## Application for a Non-Material Amendment Following a Grant of Planning Permission

Reserved matters to 15/01326/OUT - Layout, scale, appearance and landscaping for the residential development of up to 280 dwellings and 34 space car park.

19/00895/REM

Omission of 3 no. external doors

**Sports Changing Facility
Plans & Elevations**

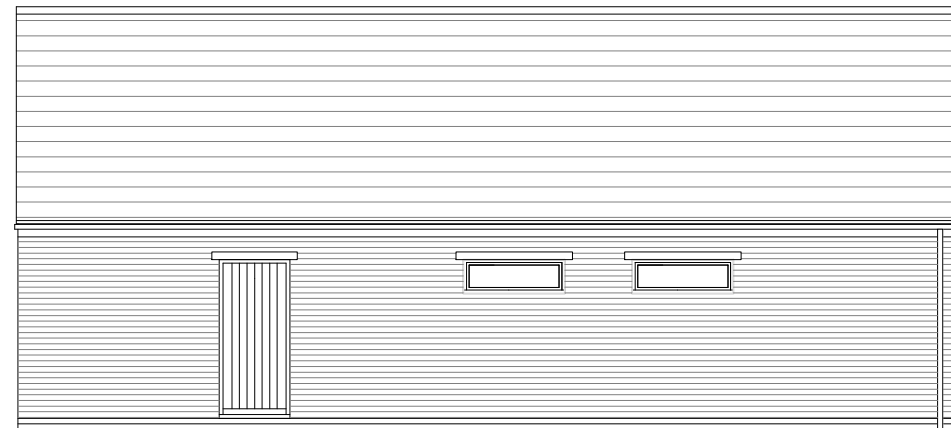
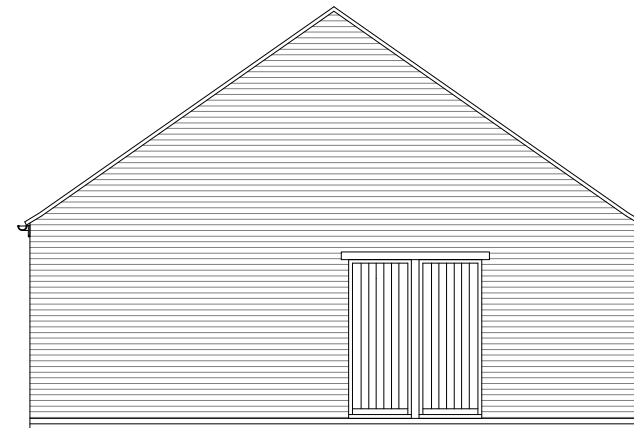
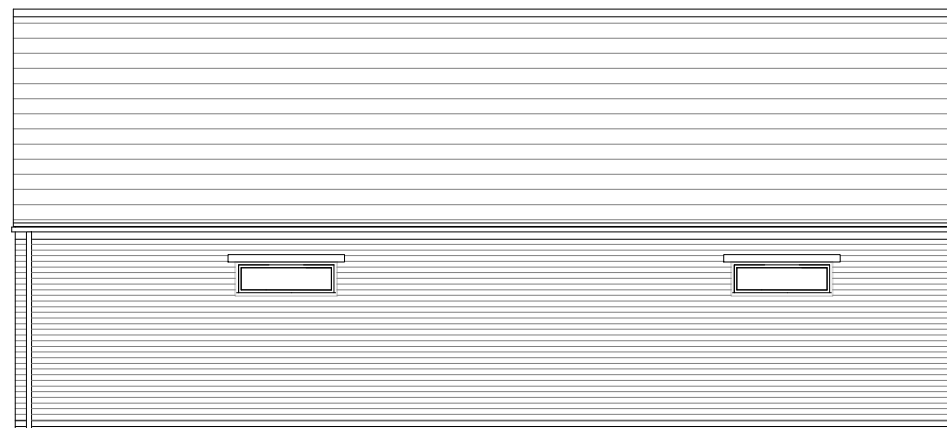
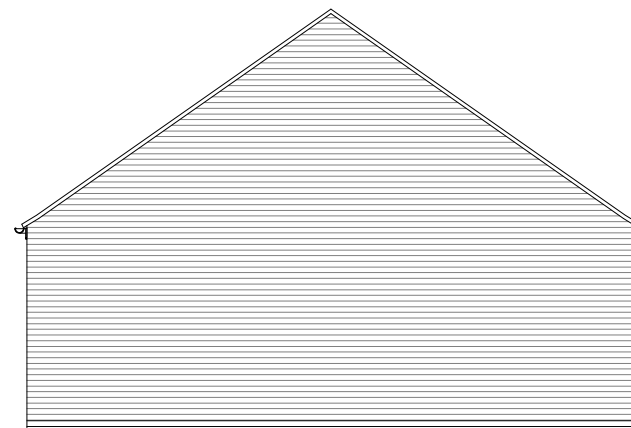
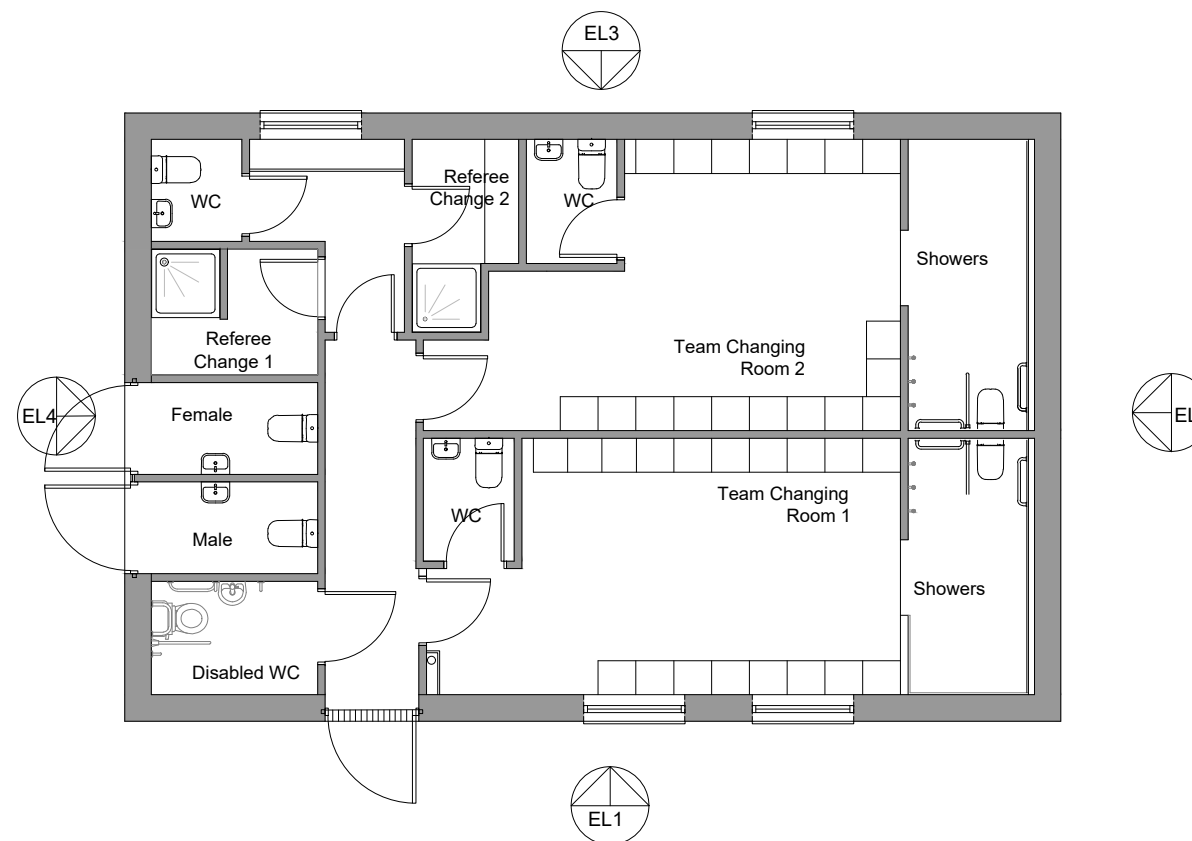
to reduce security risk and for ease of maintenance

BOD.CF.186 Rev B
